Silverado Ranch Filing No. 2
Transportation Memorandum
PCD File No.: SF246
(LSC #S224530)
June 25, 2024

Silverado Ranch, Filing 2

Transportation Memorandum

RE: Silverado Ranch, Filing 2
Transportation Memorandum
El Paso County, CO
PCD File No.: SF246
LSC #S224530

Figure 2
Filing No. 2 Site Plan
Silverado Ranch Filing No. 2 (LSC#S224530)

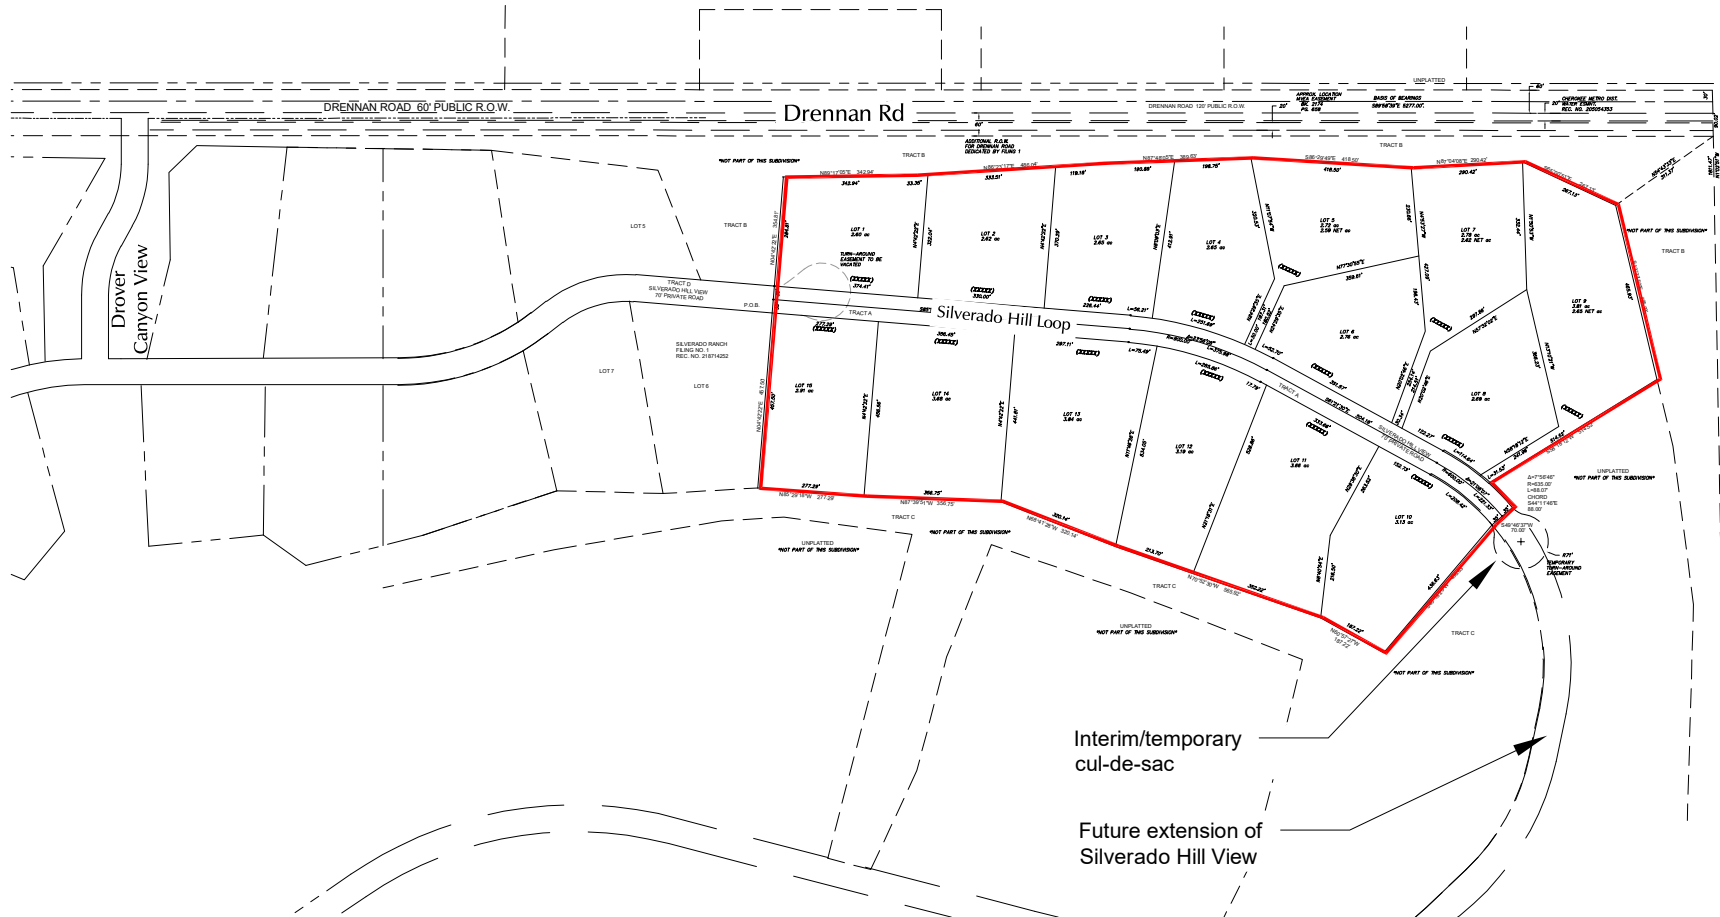
Review C1: Silverado Hill Loop per F1 plat. Please update throughout report.

Review C2: Unresolved.
